Item No. **Report of the Head of Planning, Transportation and Regeneration**

Address 67 CORWELL LANE HILLINGDON

Development: Single storey side and rear extension following demolition of existing garage

LBH Ref Nos: **75675/APP/2020/1893**

Side Elevation Drawing

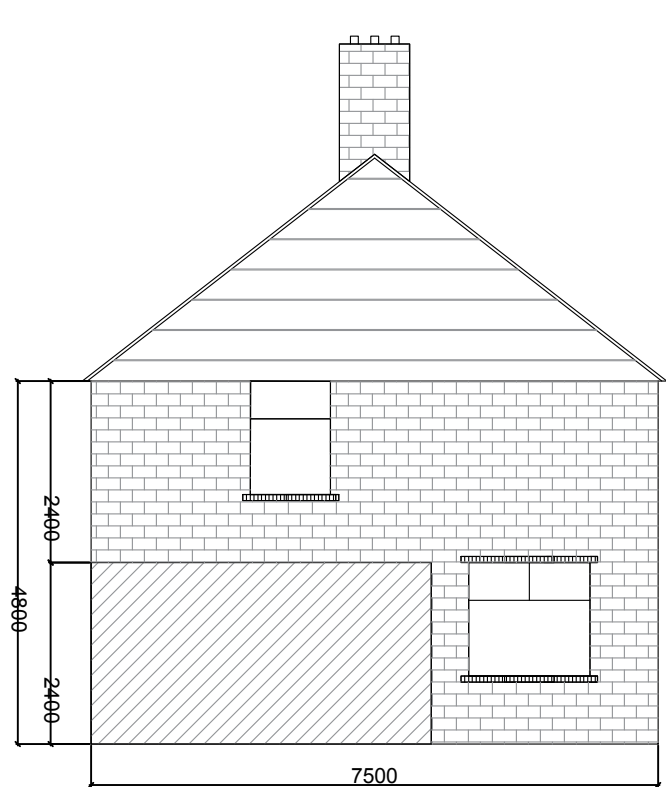
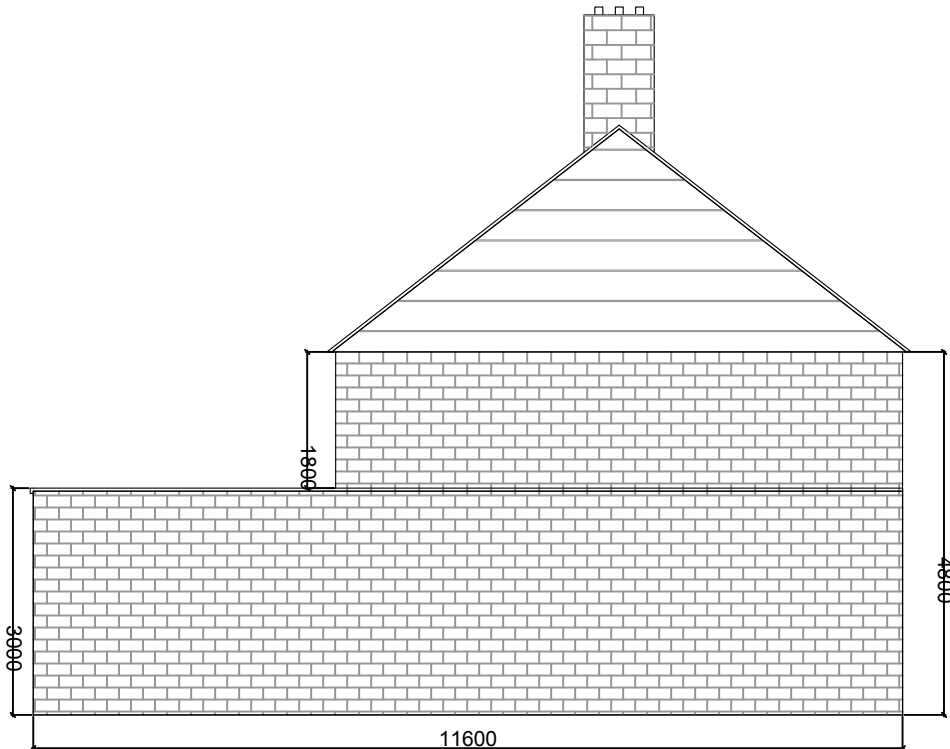
maximum height of 3 m with a flat roof. To the side, the proposed extension measures 2.35 m in width which is less than 1/2 the width of the original property and also has a 3 m height. The extensions attach, wrapping around the property. With regards to the side extension, this element is fully compliant with the policy. However, the depth of the rear extension is 0.4 m more than what is stated by the Policy and as such it is necessary to assess the impacts of the development on adjoining neighbours.
